Single storey rear extension and conversion of roofspace to habitable use to include 1 x front and 1 x rear dormer. This application may affect the character and appearance of the Aldwick Bay Conservation Area.
Cliveden Beach Close Aldwick

Thank you for your internet representation made on 30th December 2019 which has been recorded as '**an objection**' with the comments as follows:

PROPOSED NORTH ELEVATION

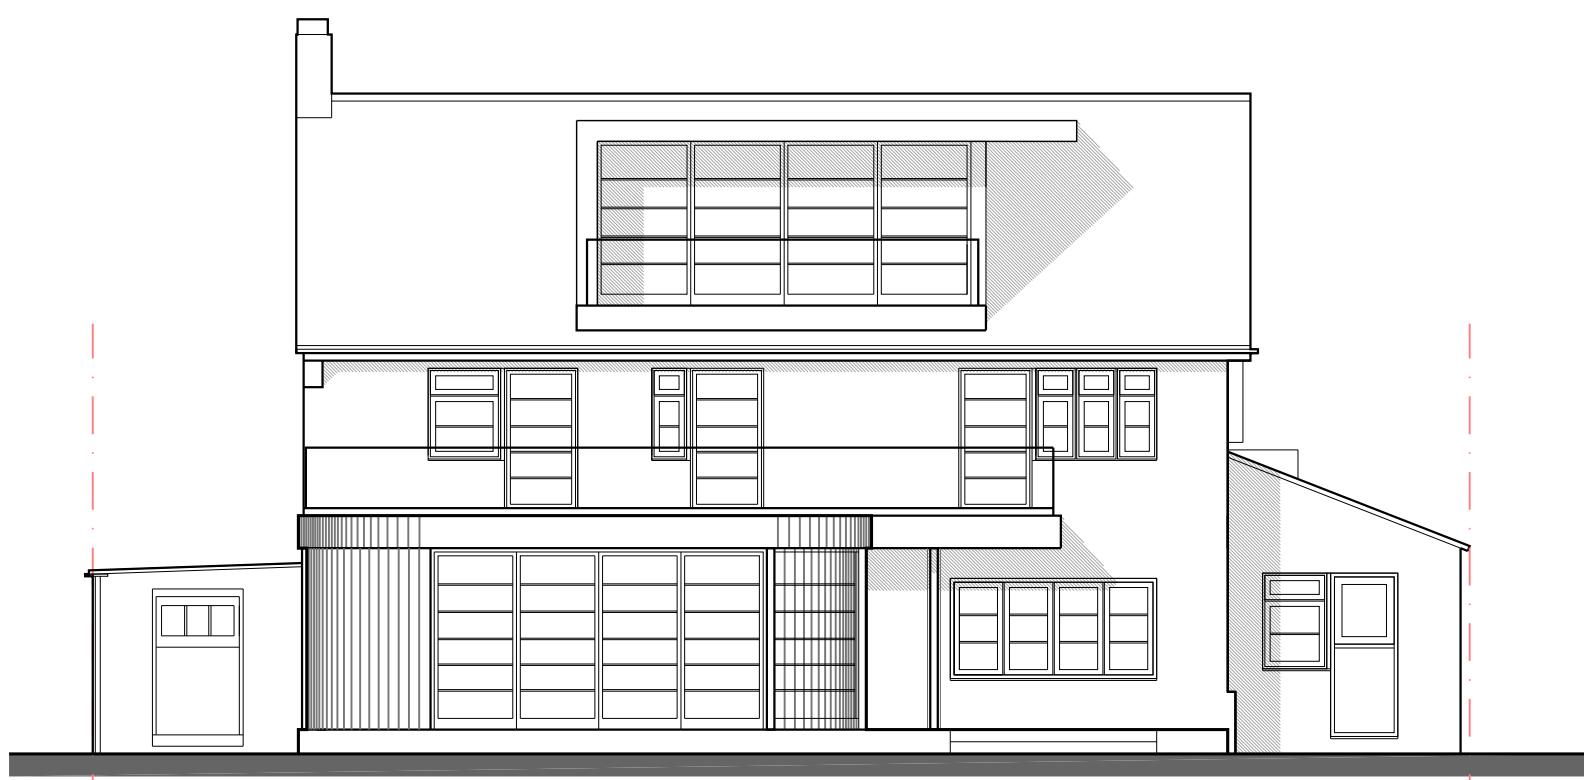
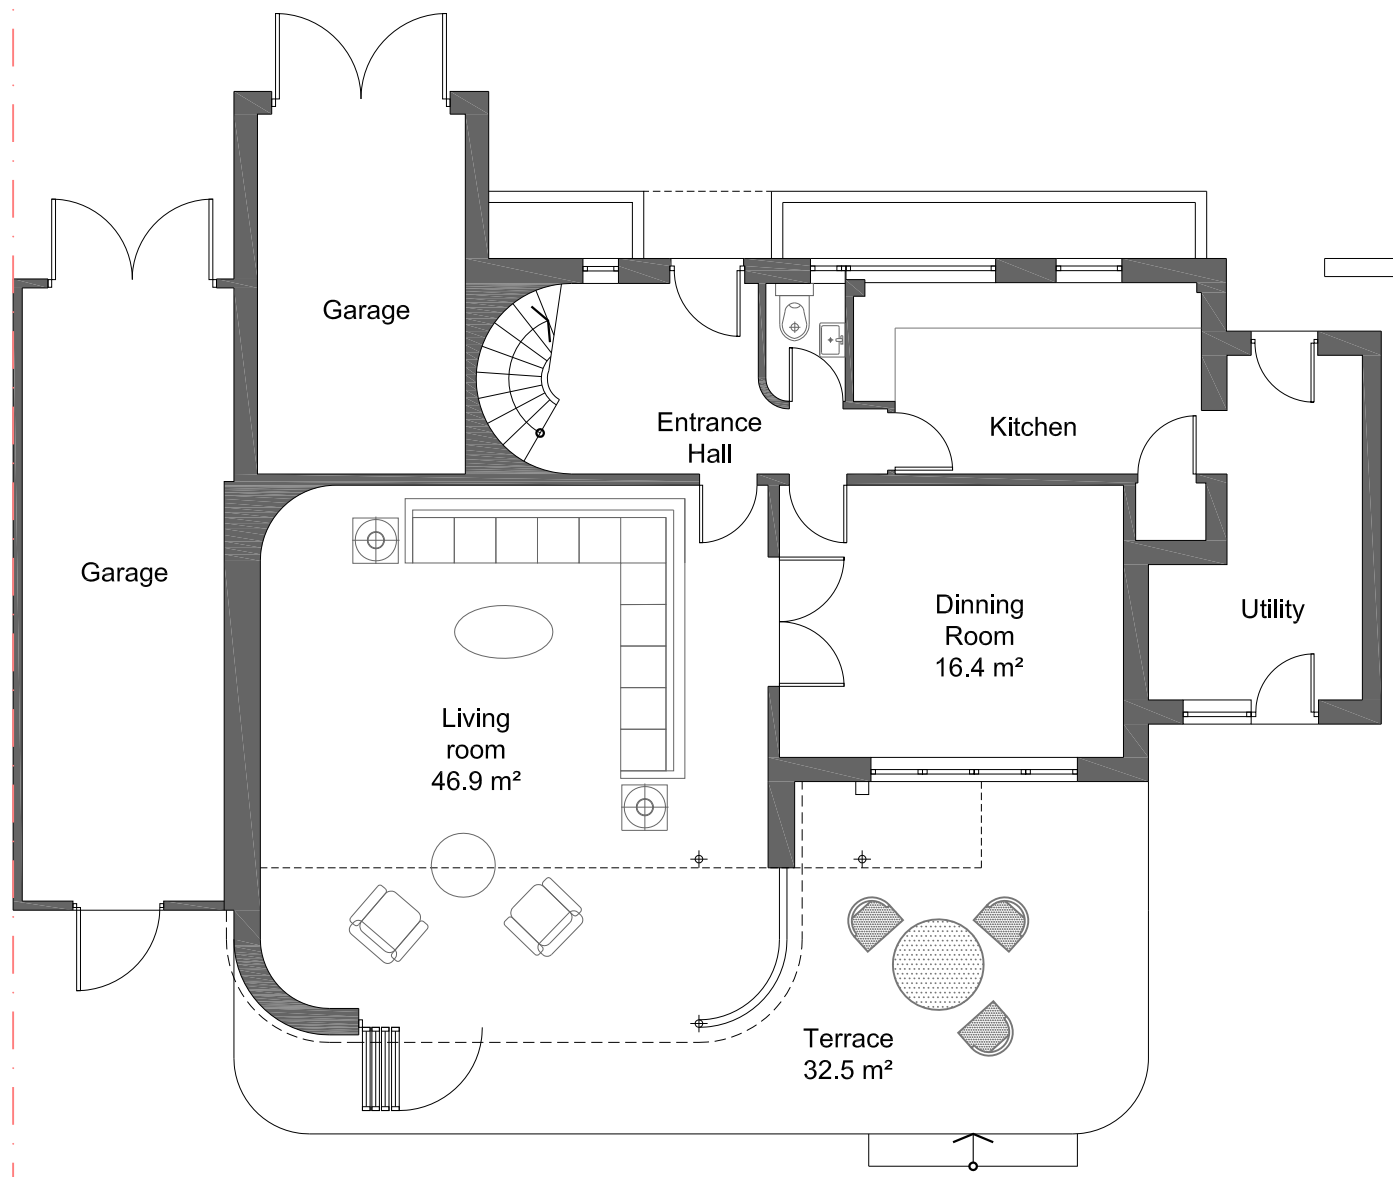
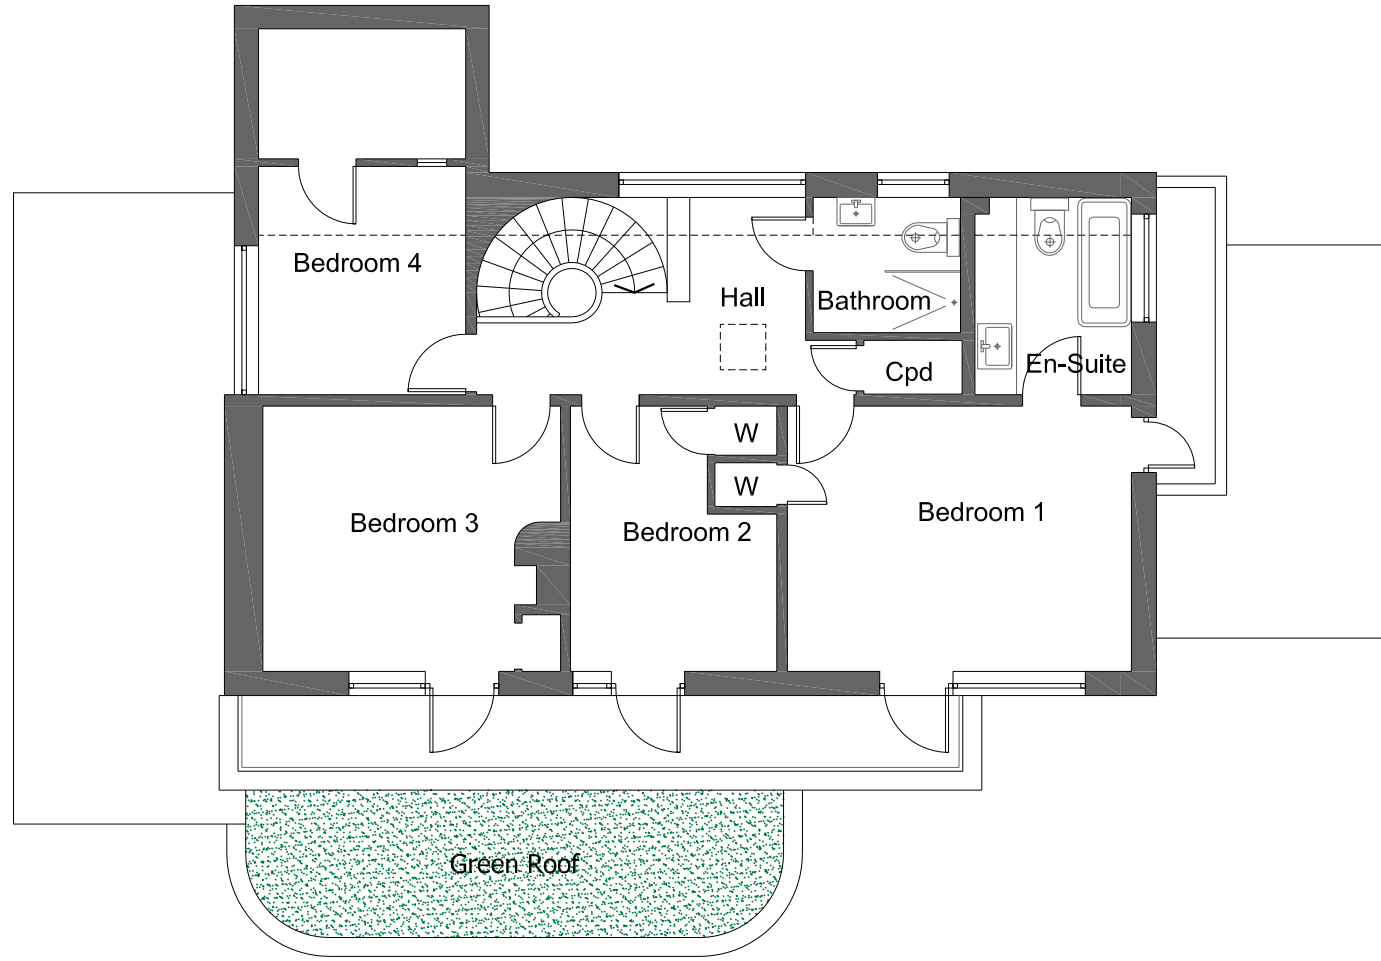
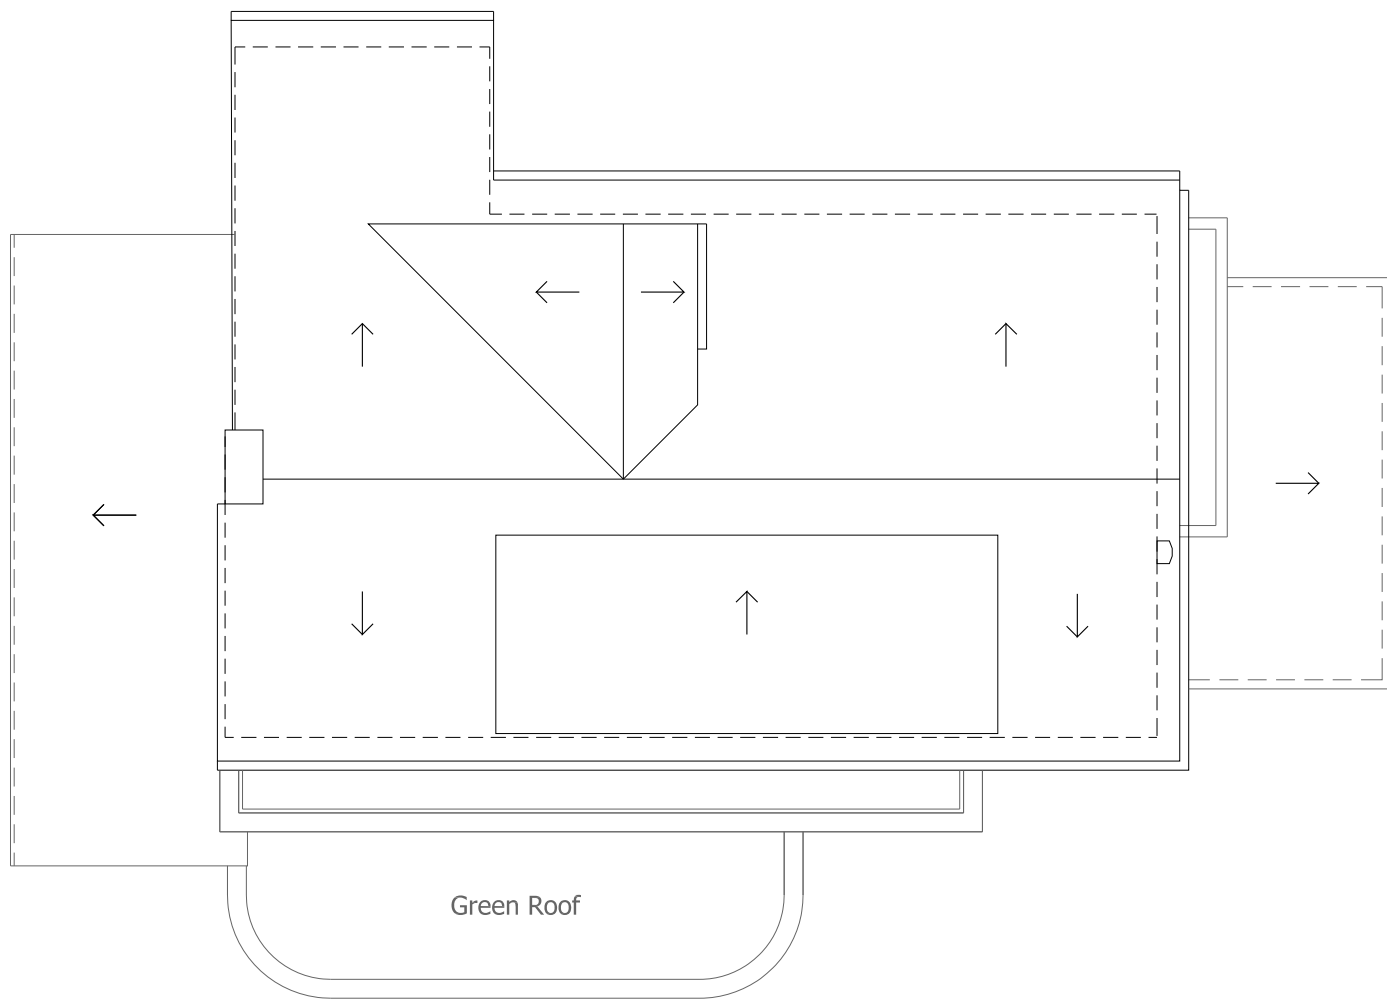
*By reason of the size, configuration and inappropriate design to the front of the property and therefore the street scene this application will be harmful to the character and appearance of the conservation area. Arun District Local Plan 2018 Policy HER DM3 (Conservation Areas) and Policies DSP1 and DDM1 (design quality).
The panels notes the good and appropriate design to the rear of the property.*
